CODE ANALYSIS

15 West Street Proposed Residential Board and Care Portland, ME

June 8, 2017

JASON LANDRY CONSULTING, LLC		
17 NASON ROAD GORHAM, MAINE 04038 207-632-3111		
JIM GRAY		
19 WEST STREET		
PORTLAND, MAINE		
TITLE: EXISTING 1st FLOOR PLAN		
DATE: 3/24/17	DRAWN BY: J.J.L.	DRAWING NUMBER:
SCALE: as noted	PROJ NO: 2017-028	FP-1

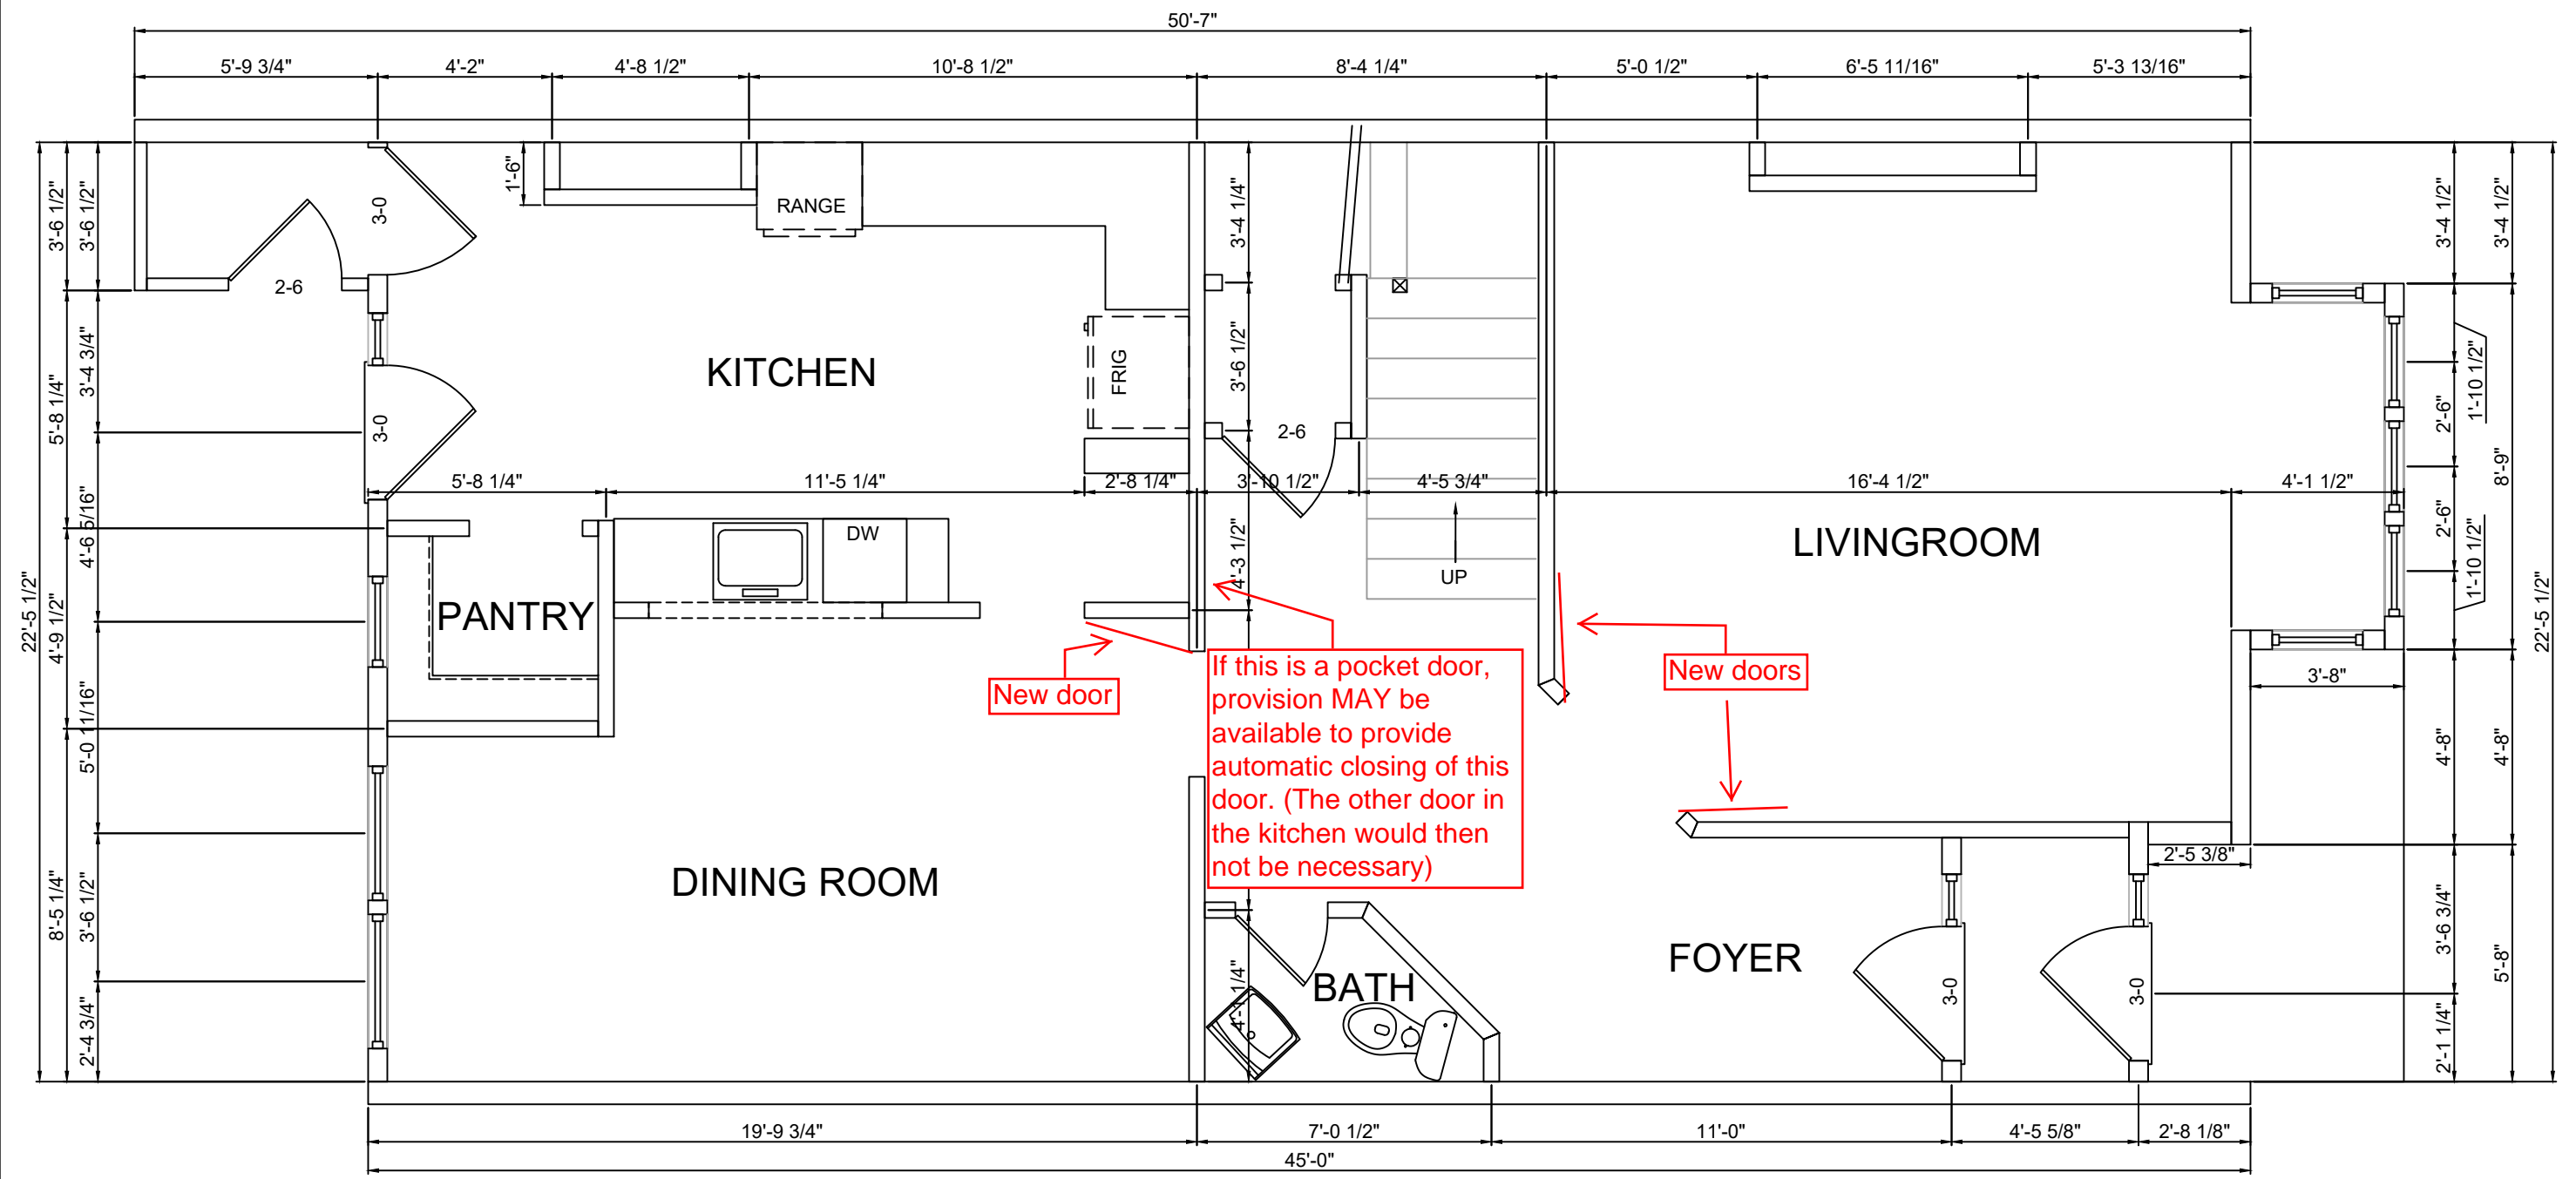
Due to the configuration of the first floor of the subject property, additional automatic closing doors would need to be added at the entrance to the living room and to the dining room, as shown on the attached floor plans (in red). One additional door may be required for floor two (if provisions for automatically closing the existing pocket door are not applied).
